From: Sarah Burrow <Sarah.Burrow@arun.gov.uk>
Sent: 05 June 2020 10:32
To: Planning.Responses <Planning.Responses@arun.gov.uk>
Cc: Maria Tomalova <Maria.Tomalova@arun.gov.uk>
Subject: RE: Planning Consultation on: FP/61/20/PL

Engineers Comments Regarding Surface Water Drainage

Application No: FP/61/20/PL
Registered: 5th May 2020
Site Address: 10 Felpham Gardens Felpham PO22 8QS
Grid Reference: 495908 100133
Description of Works: Demolition of 1 No. house & erection of 2 No. chalet style dwellings with garaging & car parking (resubmission following FP/274/18/PL).

SITE PLAN - 1/500

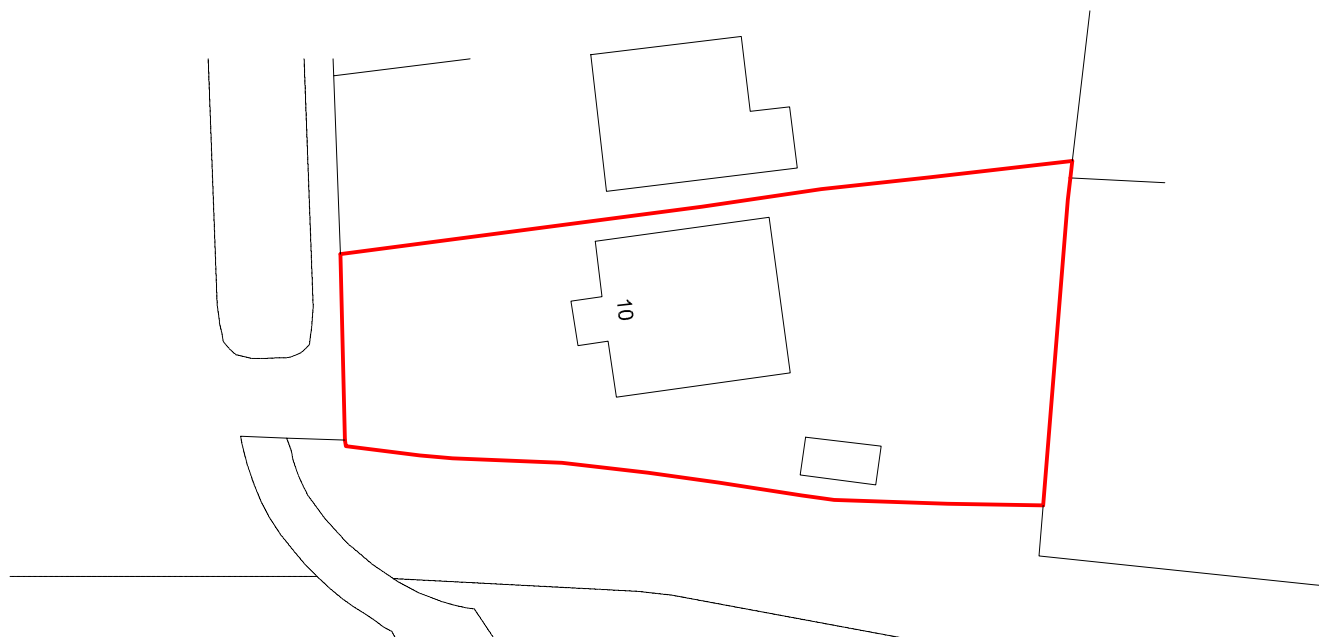
The applicant has stated that they intend to drain surface water via soakaways which we support. However, these must be located a minimum of 5m from the buildings and 2.5m from property boundaries. The only area of the site where this could be accommodated is on the eastern side. It is likely that both properties will have to drain to a single soakaway here. The site investigations (groundwater monitoring and infiltration testing in accordance with BRE365) should be focussed in this area.

"Development shall not commence, other than works of site survey and investigation, until full details of the proposed surface water drainage scheme have been submitted to and approved in writing by the Local Planning

Authority. The design should follow the hierarchy of preference for different types of surface water drainage disposal systems as set out in Approved Document H of the Building Regulations, and the recommendations of the SuDS Manual produced by CIRIA. Winter groundwater monitoring to establish highest annual ground water levels and winter Percolation testing to BRE 365, or similar approved, will be required to support the design of any Infiltration drainage. No building / No part of the extended building shall be occupied until the complete surface water drainage system serving the property has been implemented in accordance with the agreed details and the details so agreed shall be maintained in good working order in perpetuity."
